## Department of Transportation

July 5, 2023

RE: CS231 - Jubilee Group Rezone 11401 E Highway 24, Peyton

The submittals for Jubilee Group Rezone received June 26, 2023 have been reviewed by CDOT Access Management. Our comments follow:

**ZONE CHANGE
MAP**

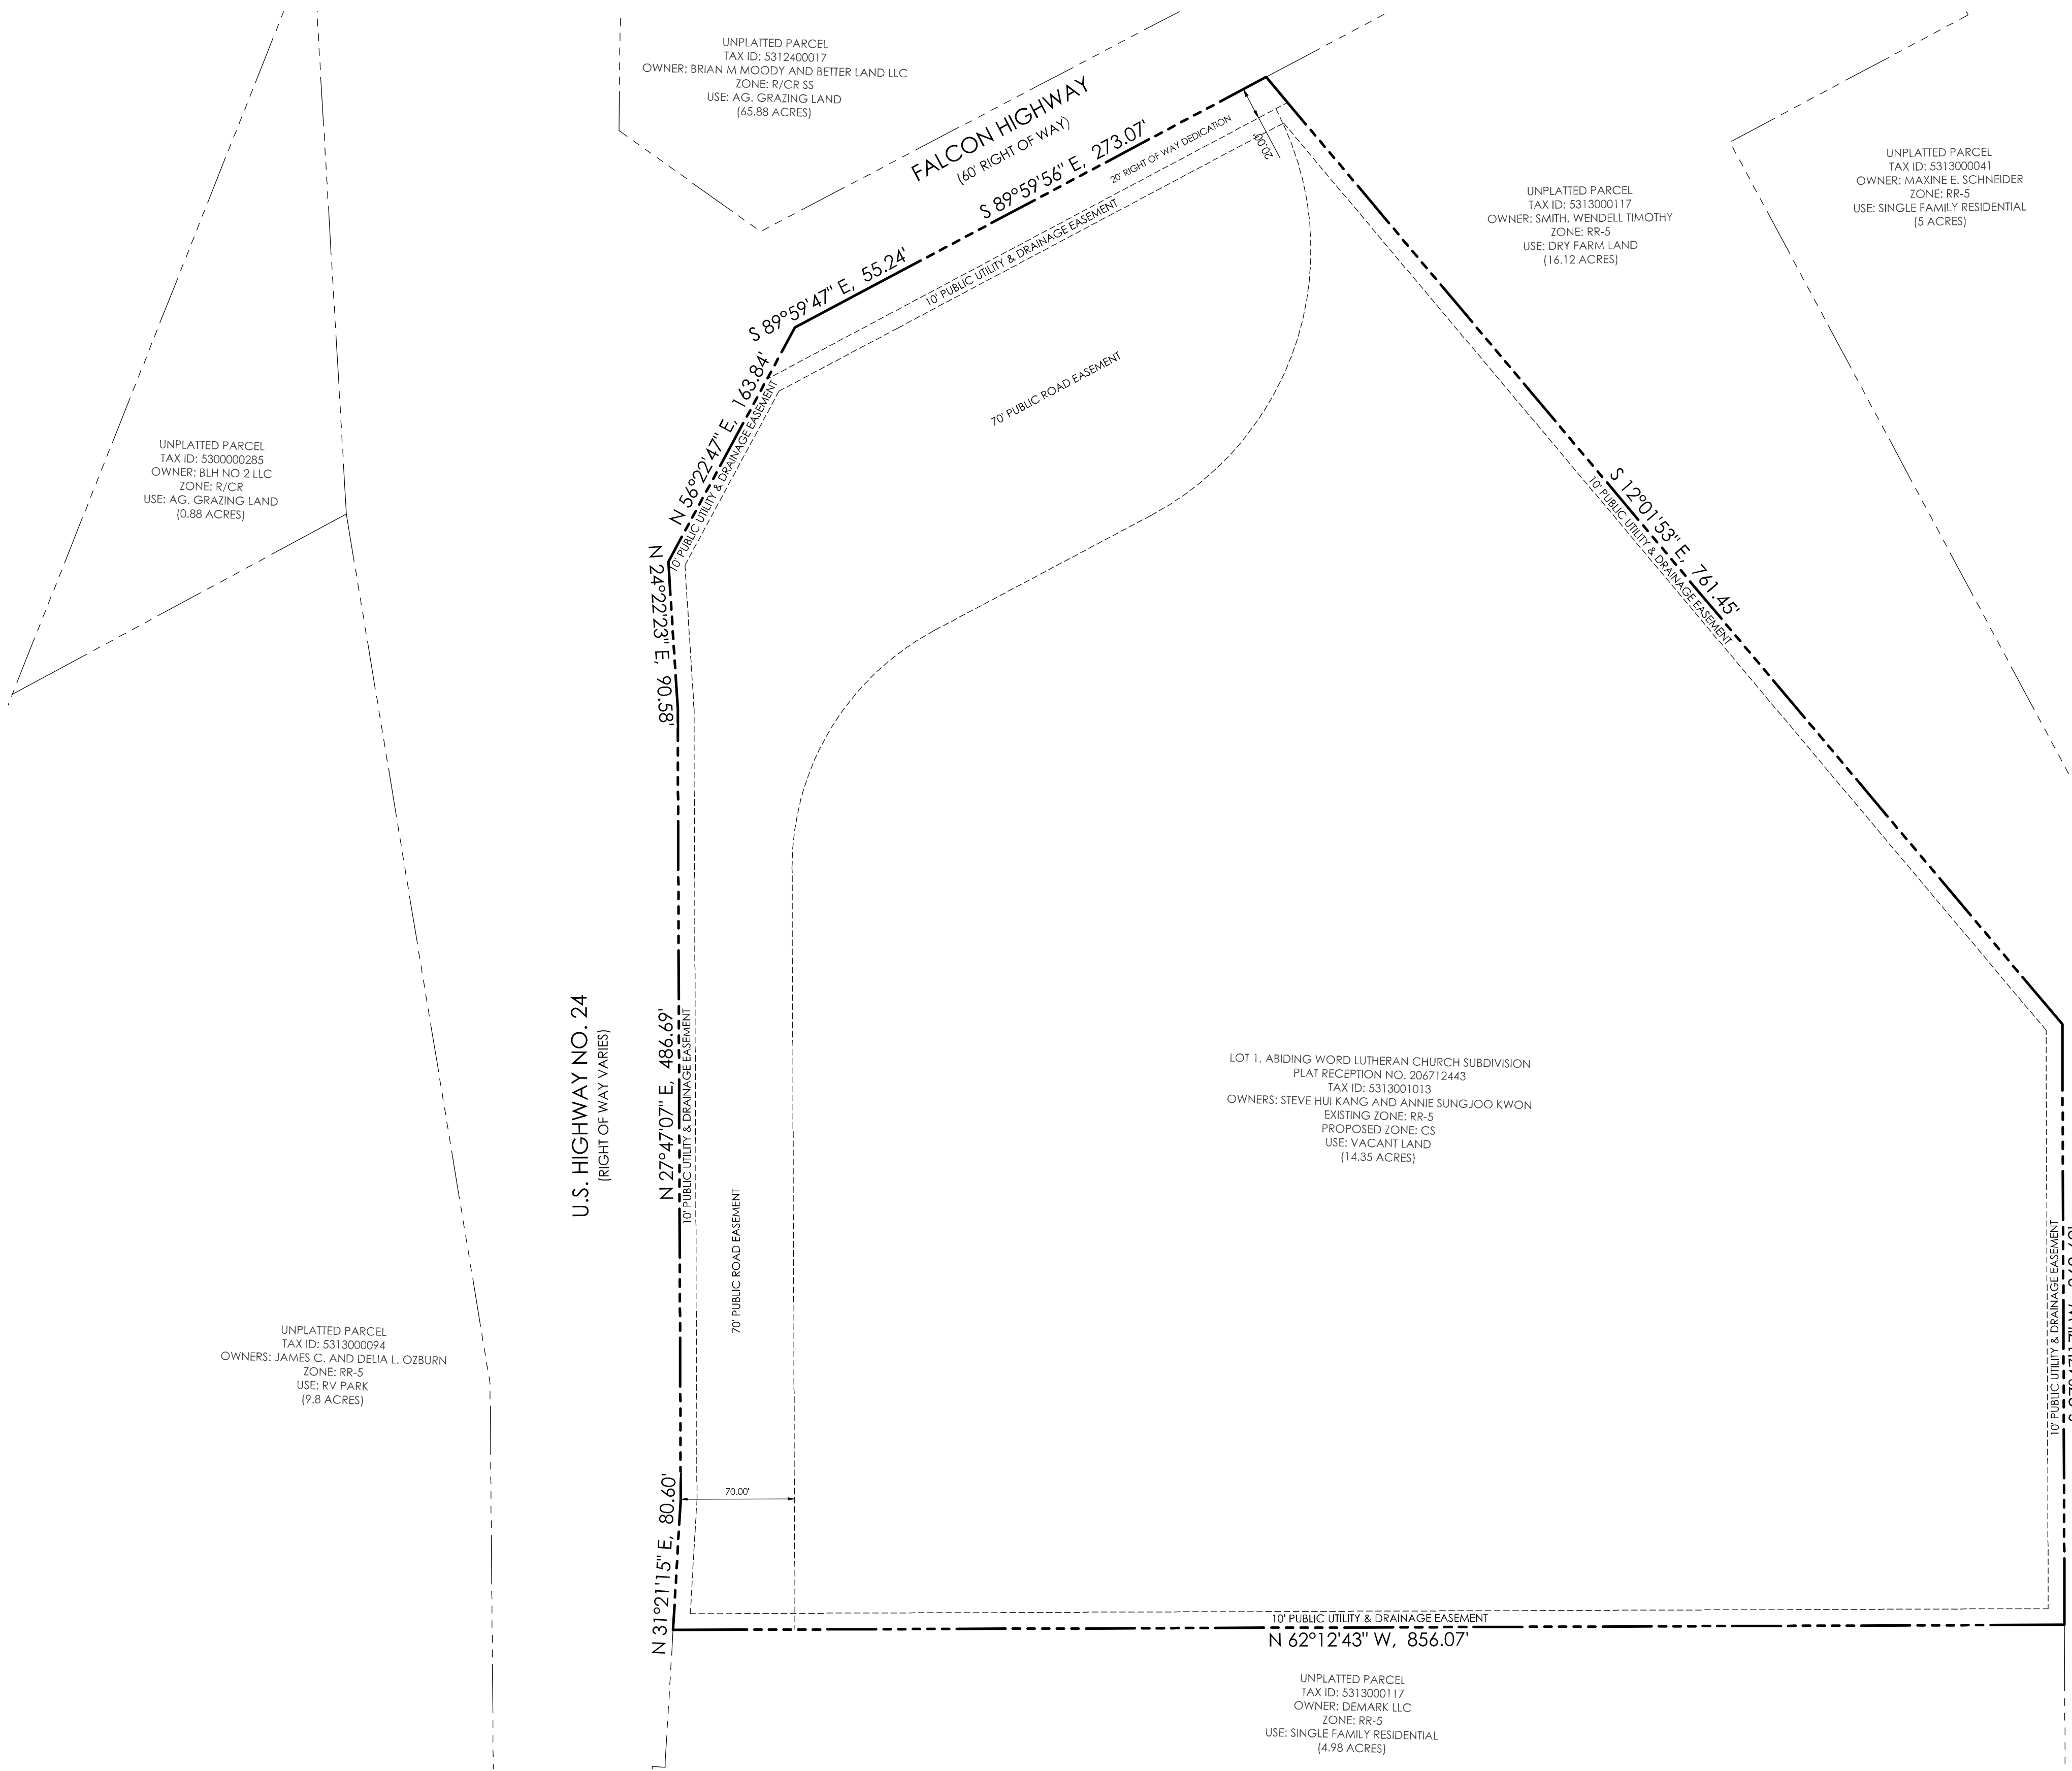
- No public improvements are required; trip generation is less than 20%.
- CDOT requests right-of-way donation/dedication/reservation along US24 and Falcon Hwy for future public improvements at the intersection.
- The site access will ultimately be restricted to right in/out sometime in the future.

- US Hwy 24 is planned to be widened through the Falcon area.
- State Highway Access Permit may be required for the change in use per State Highway Access Code §2.6 for any connections to Highway 24G.
- SH24G is categorized as E-X (Expressway); no direct access to Highway 24 will be allowed.
- Request review of subdivision plat at Site Development Plan stage
